From: Paul Cann <Paul.Cann@arun.gov.uk>
Sent: Wednesday, May 24, 2023 3:13 PM
To: Planning.Responses <Planning.Responses@arun.gov.uk>
Cc: Karl McLaughlin <Karl.McLaughlin@arun.gov.uk>
Subject: RE: Planning Consultation on: P/88/22/DOC

Application No: P/88/22/DOC
Registered: 24th May 2022
Site Address: Land North of Sefter Road & 80 Rose Green Road Pagham
Description of Works: Approval of details reserved by condition imposed under P/134/16/OUT relating to conditions 10-surface water drainage, 12-maintenance and management of surface water drainage system, 14-foul drainage system, 16-external lighting, 17-Construction Management Plan, 22-setting out when roads, footpaths, cycleways and emergency routes are to be construction, 26-street lighting and 28 (part)-energy conservation and renewable energy.

North of Sefter Road, Pagham – P/88/22/DOC Comments Tracker				Initial Issue Date: 12-10-2022 Issue Date: - Revision 1.2	
	ADC Drainage Comments 11-10-22	Applicants Response	ADC Drainage Comments 18-11-22	Applicants Response	ADC Drainage Comments 25-01-23
I hereby confirm the surface water drainage design and maintenance manual is satisfactory and recommend discharge of conditions 10 &

| 10768/1637     | P5   |

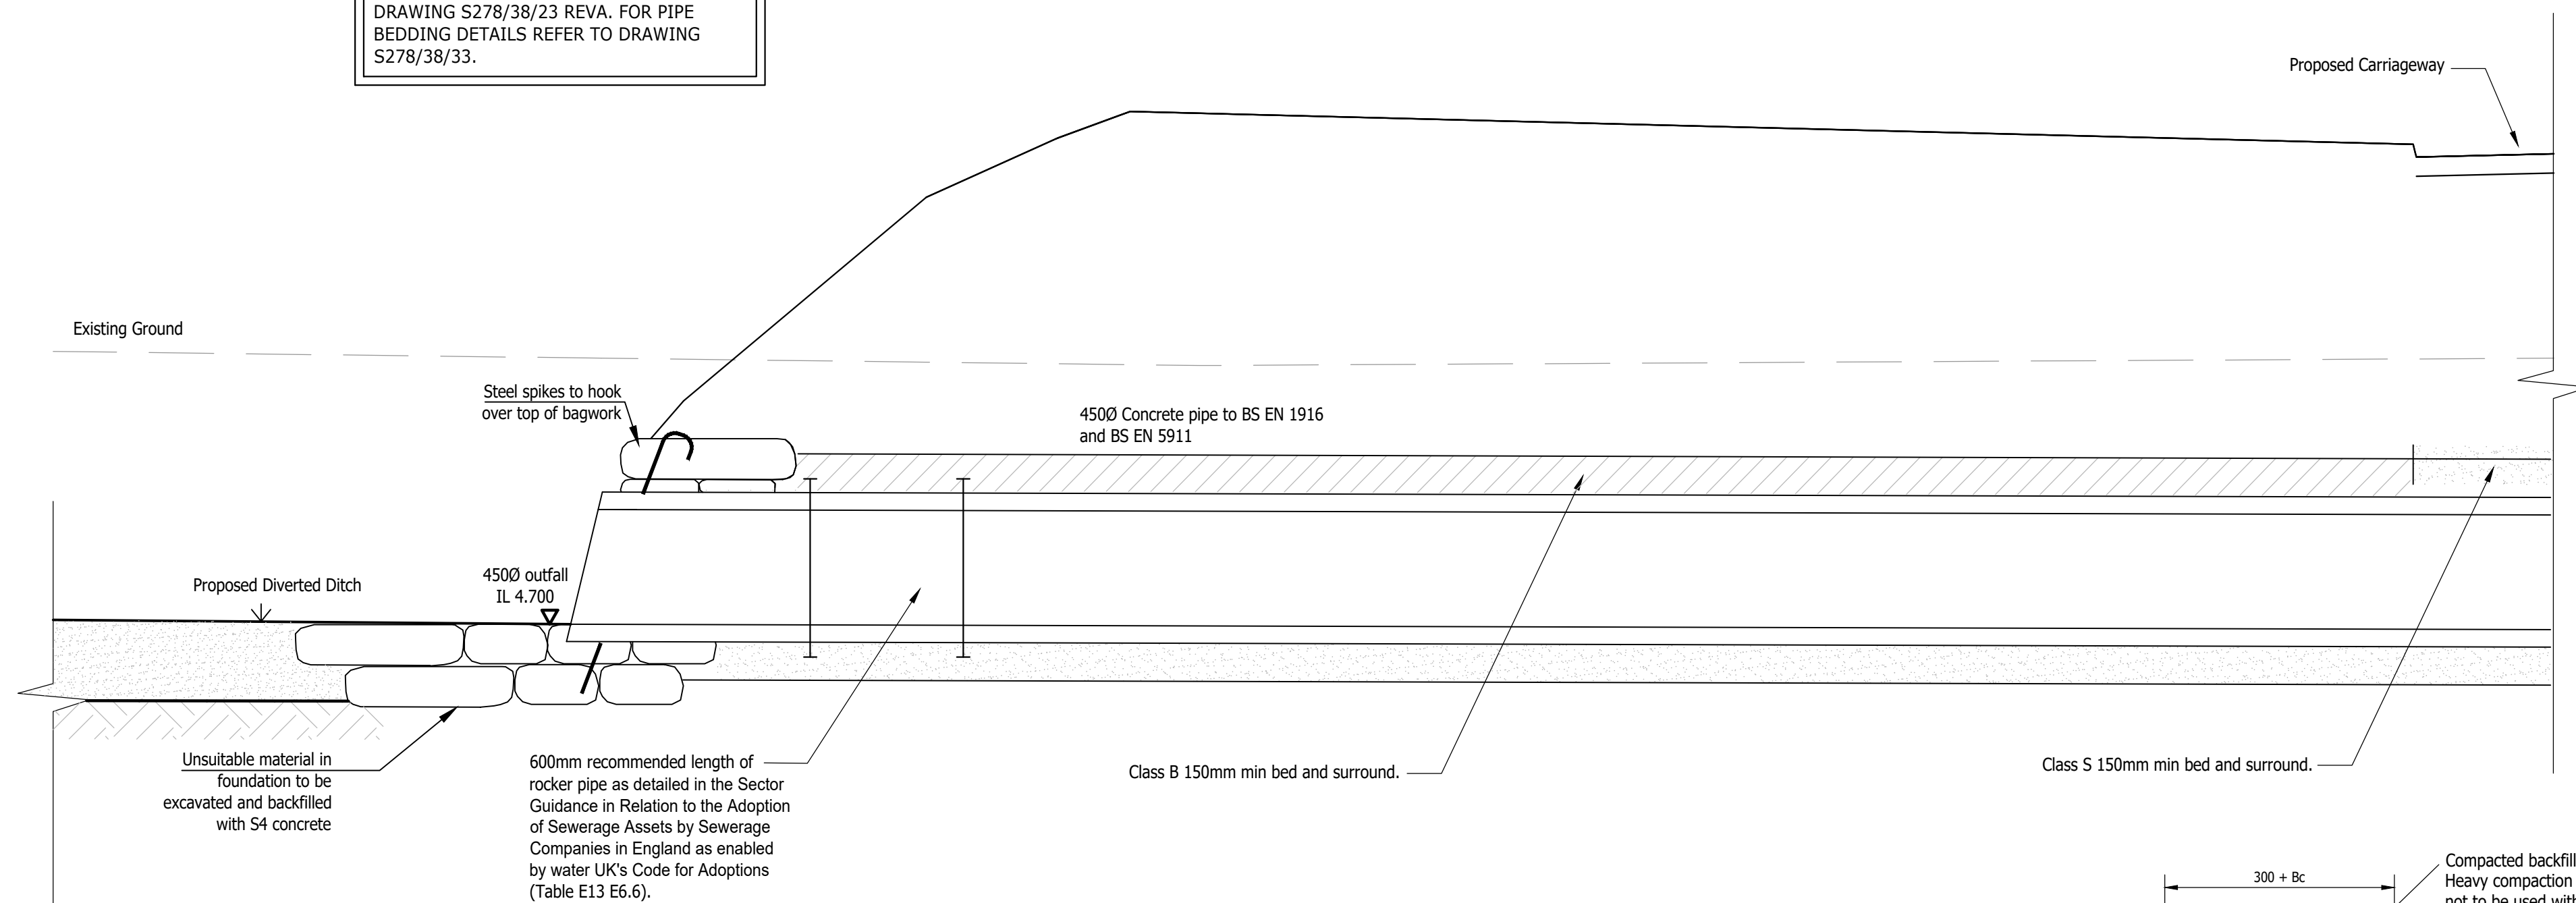
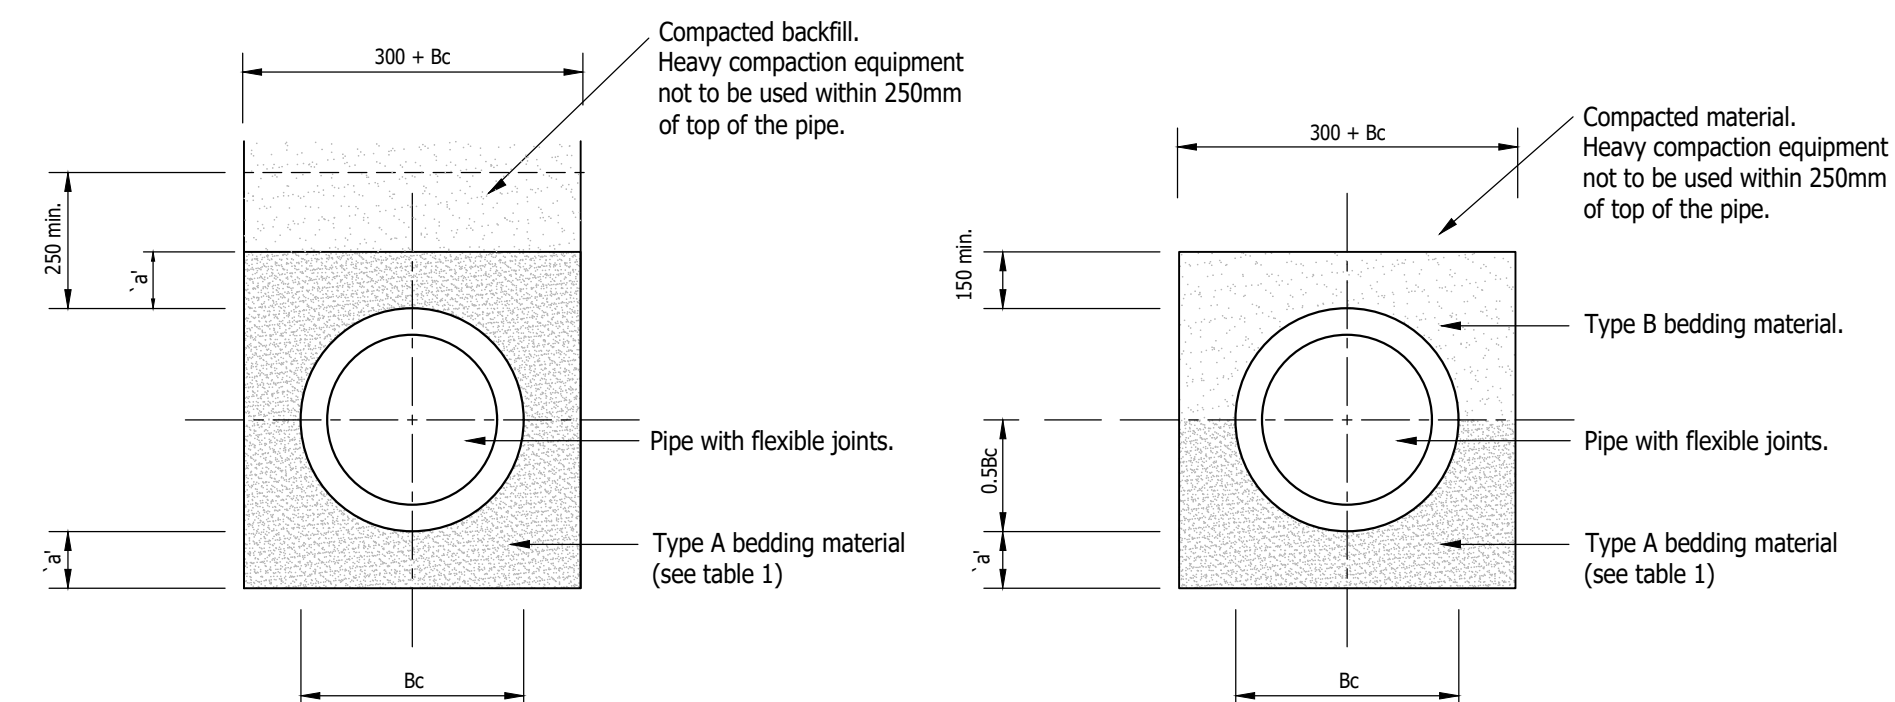
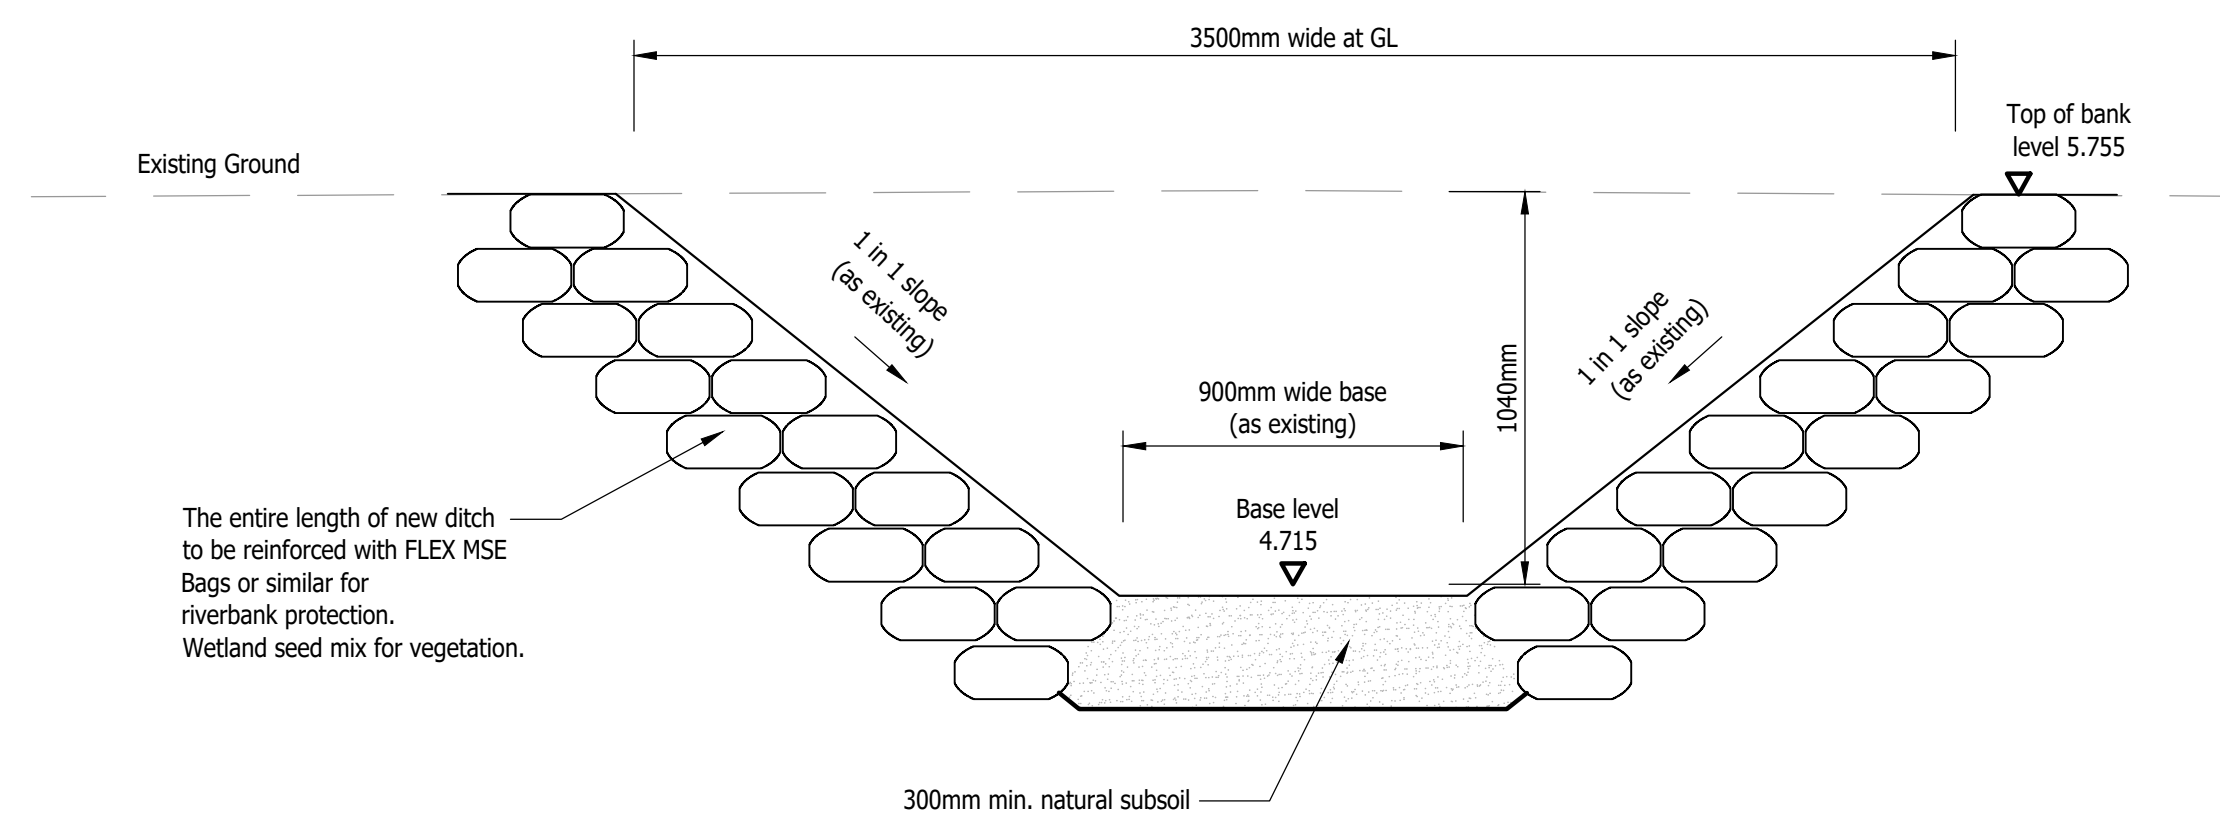
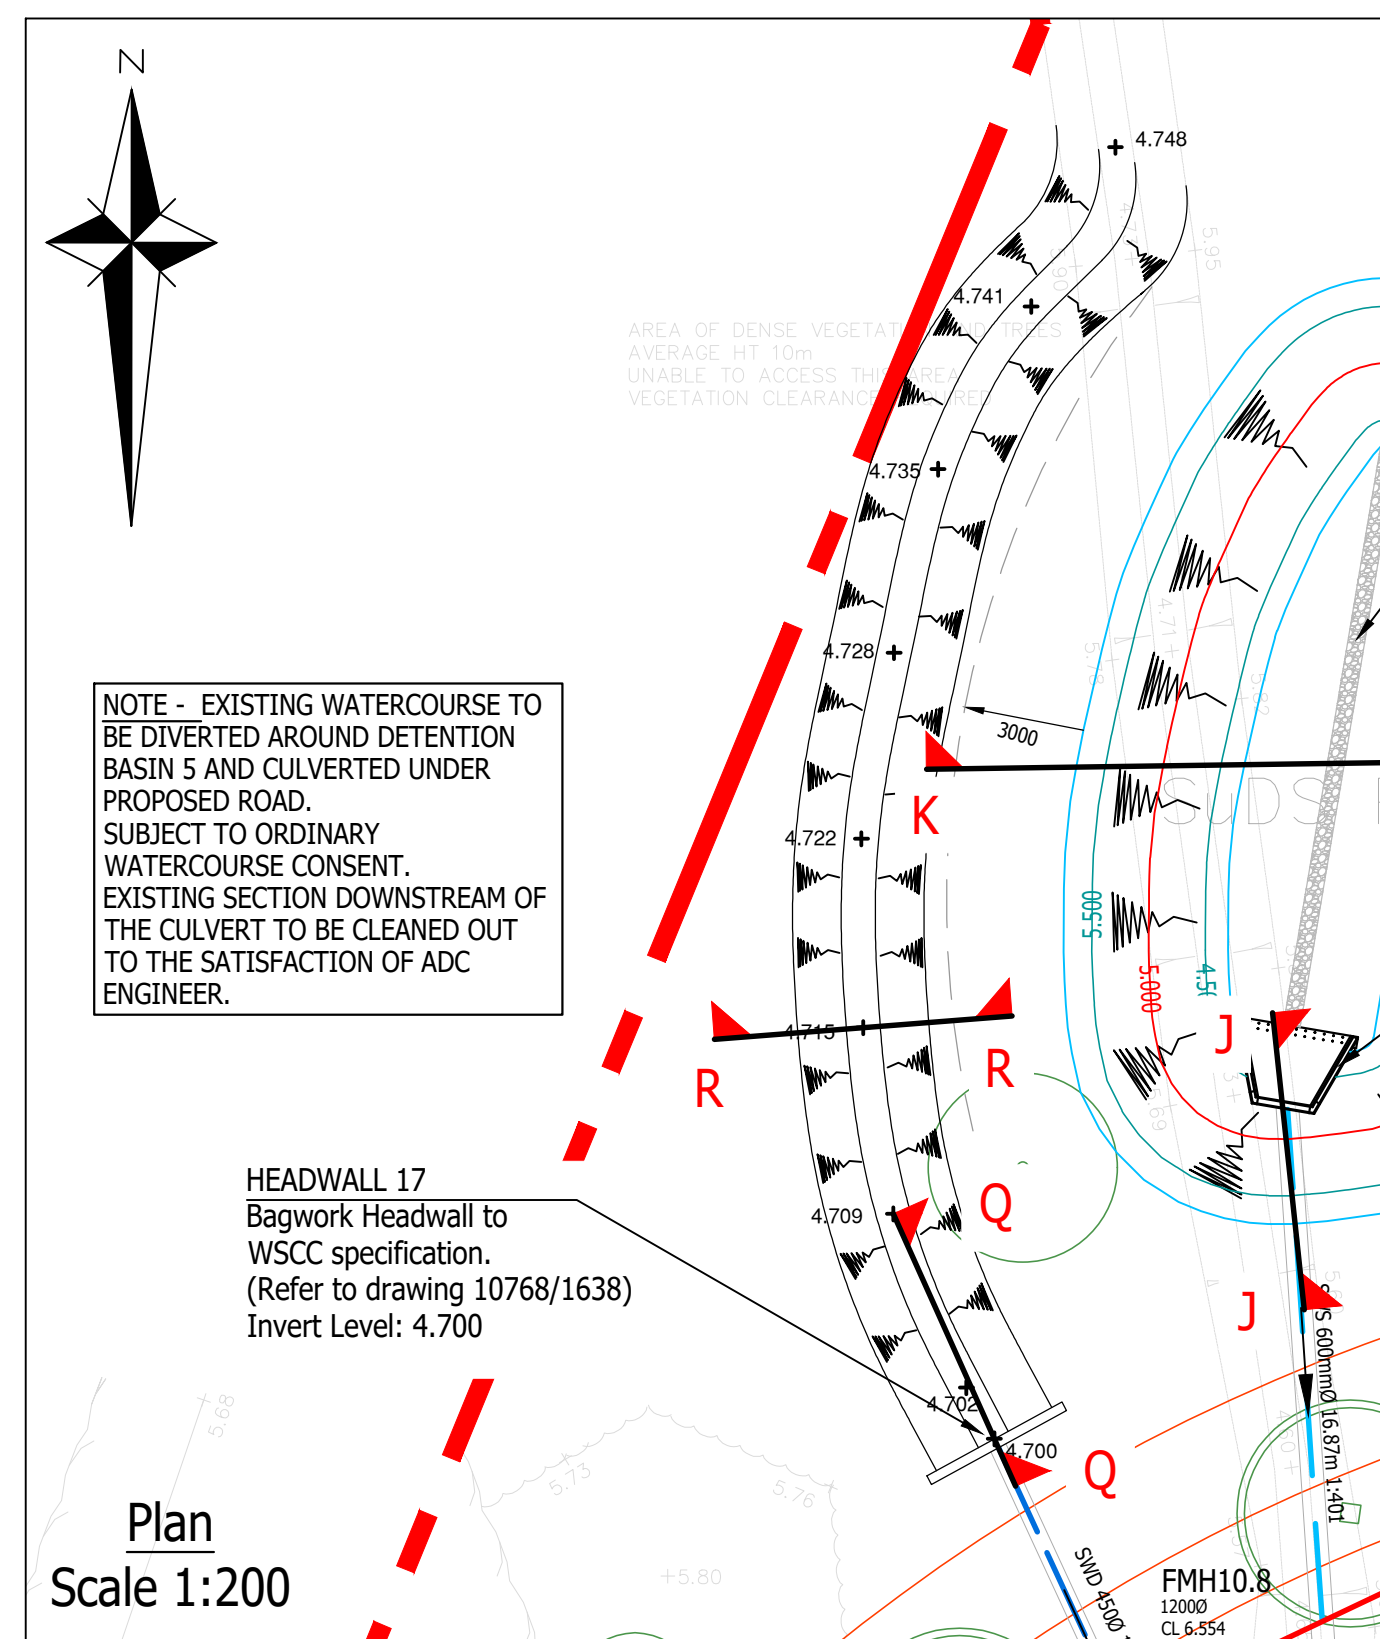
10.	With reference to drawing 1602/P6 the buffer in between the diverted watercourse and SW basin 5 does not comply with the minimum 3.0m.	Proposed diversion and pond orientation adjusted to comply with 3m requirement.	Agreed and closed.	-
